**RE: Application by Highways England for an Order Granting Development Consent for the A30 Chiverton to Carland Cross scheme**  
**Your Ref: TR010026**

# **Proposed A30 Chiverton to Carland Cross Development Consent Order**

## **PINS Reference TR010026**

### **Local Impact Report on behalf of Cornwall Council**

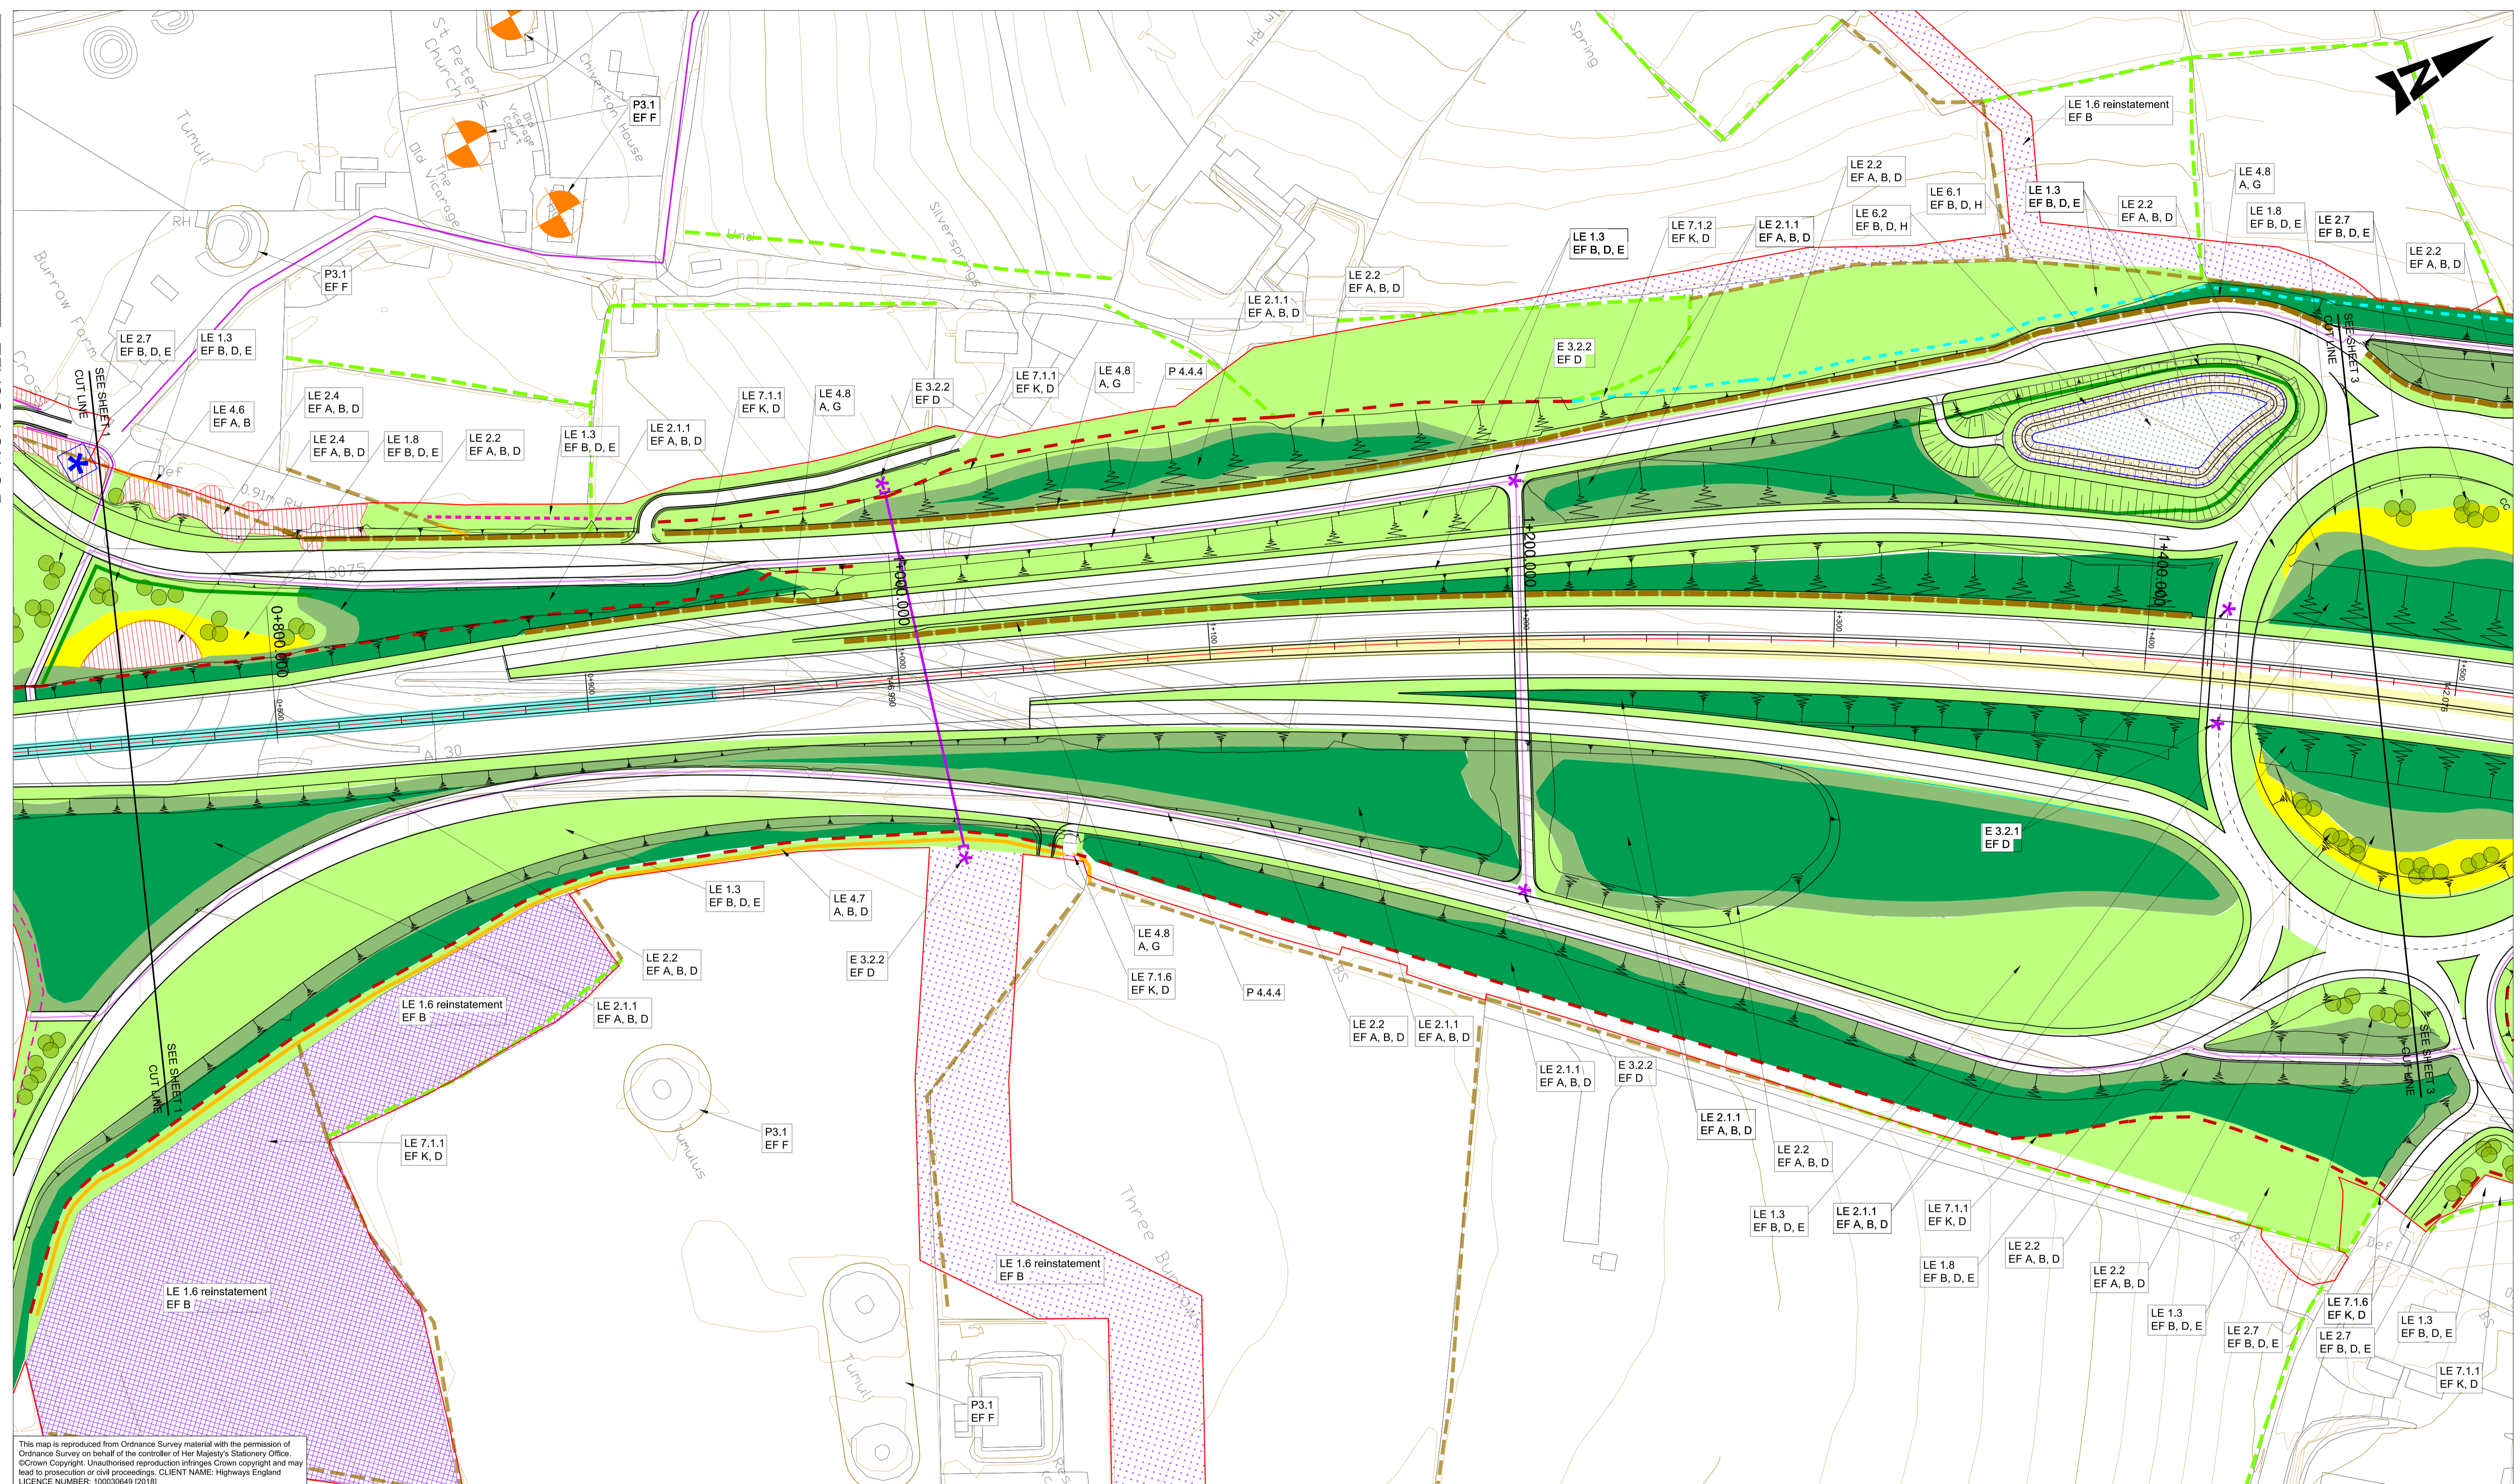
- 9.12 VP27 – winter view year 1 and 15 – the Council considers that a Cornish hedge with grass top would be preferable to a post and rail fence.
- 9.13 VP30 – drawing Figure 7.6 Environmental Masterplan 2 of 20 shows a Cornish hedge which would be planted (LE 4.8). Therefore the 15 year winter view should not then show a flat topped hedge, as vegetation would obscure this. Figure 7.6 Environmental Masterplan 2 of 20 also shows woodland edge scrub to the slope below the hedge, so after 15 years the hedge would more than likely be completely obscured from this view

- 9.16 Plan 2 - the Council notes that tree planting has been removed from the areas between roads to the south east of the multi species crossing. Deciduous native planting is requested here.

Drawing file: TR010026 / TR010026-000246-6.3 ENVIRONMENTAL STATEMENT FIGURE 7.6 ENVIRONMENTAL MASTERPLANS, SHEET 2.pdf

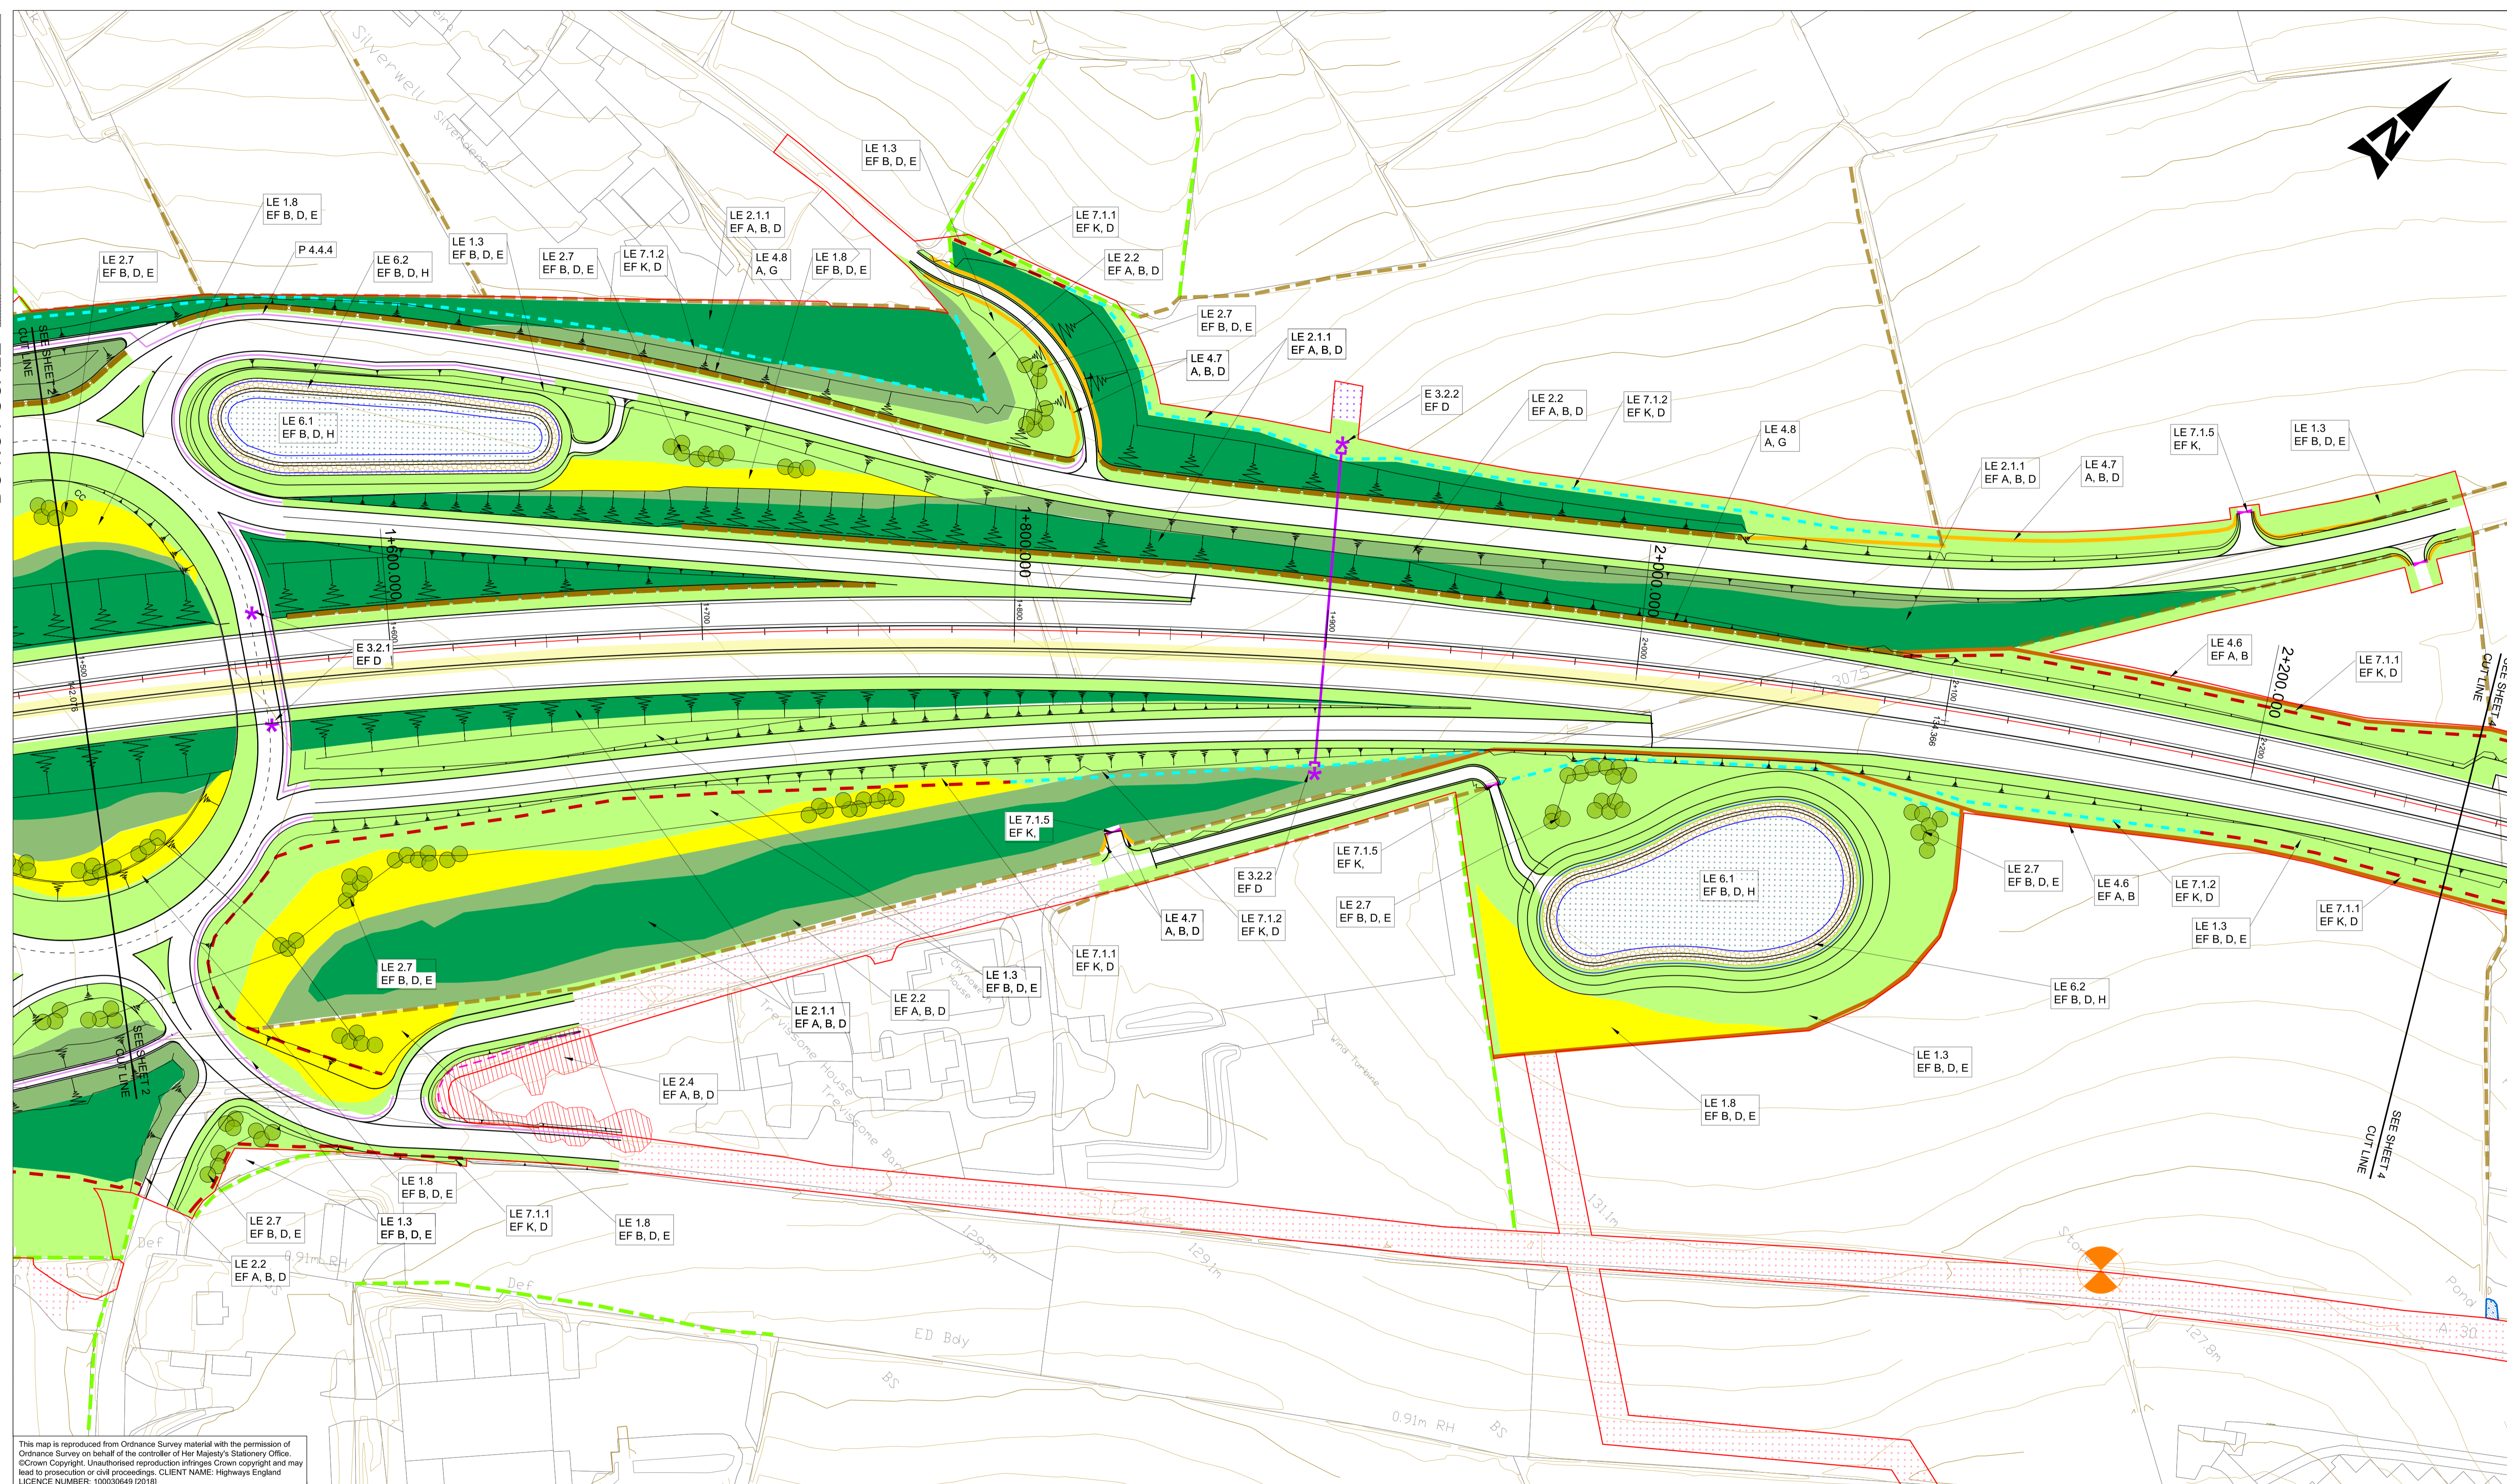
- 9.17 Plan 3 - the Council considers that post and rail fences on the top of elevated banks are not encouraged and would give rise to a landscape and visual impact and should be replaced with a suitable alternative.
